From: Simon Davis
Sent: 08 October 2025 17:58
To: 'cheryl wellstead' [REDACTED]
Subject: RE: Y/57/25/PL Sunnymead

STREET SCENE - Viewed from North End Road [1:200]

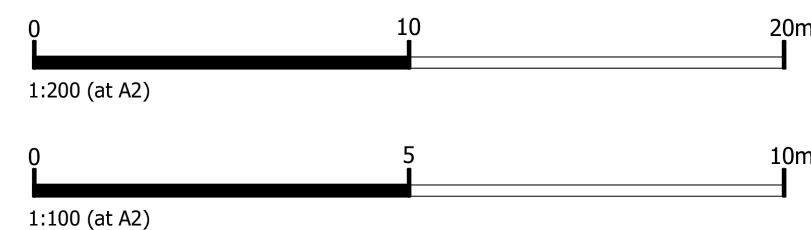
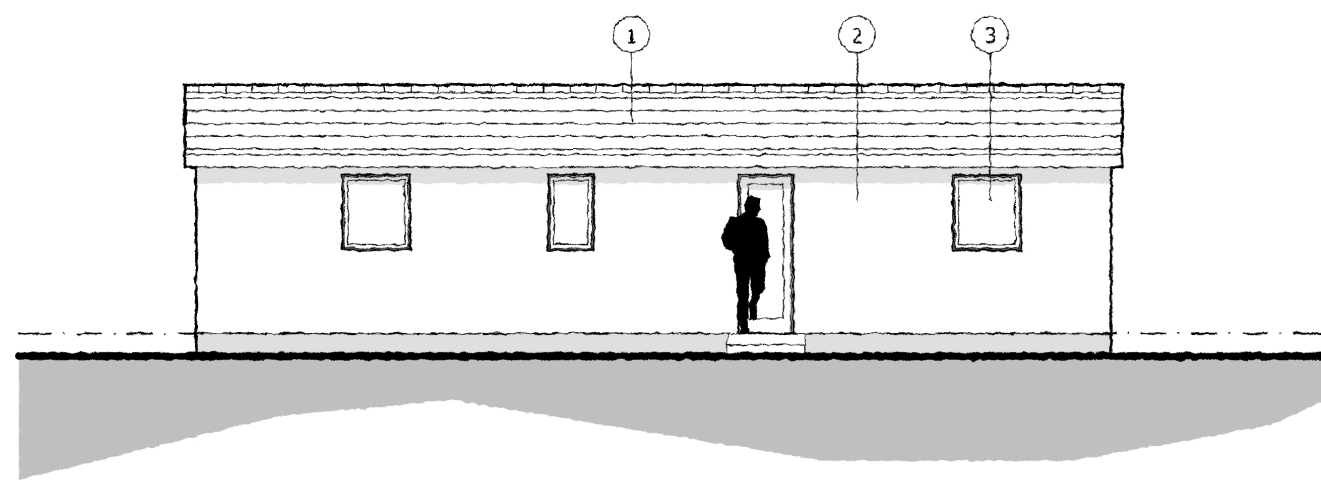
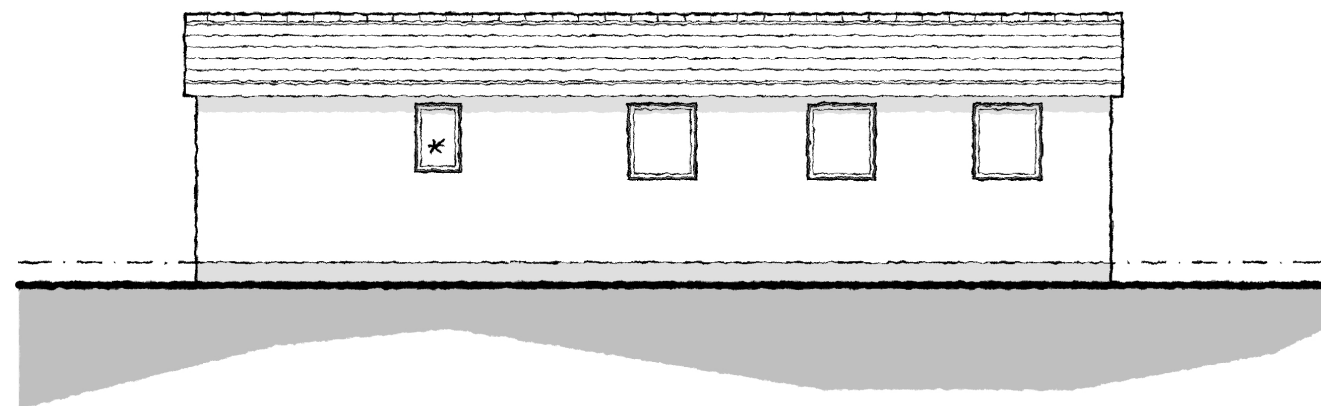
If the plans are changed to state that the fence will be lowered to a max of 1m and that a 2m specimen hedge planted behind, then this would alleviate my concerns with the impact of the fence and the mobile homes on character/the streetscene and potentially allow for a positive recommendation. We could impose a condition to require the hedge as part of the landscaping scheme, but it would help if it was also mentioned on the plans. Provided the proposed landscaped buffer is planted as per the plans then there is no need to do the same with the northern boundary.

I understand that you spoke with Mr Brazil regarding the proposed mobile homes at Yapton and the fencing along the frontage. He has confirmed that he is happy to reduce the height of the fence to 1m and plant an 8 ft specimen [ready] hedge behind it, and along the boundary adjacent to the railway line, although this currently is shown as having an acoustic fence. I can update the drawings accordingly. The hedge planting will be reminiscent of the frontage before the renovations of the site and bungalow and soften the appearance.
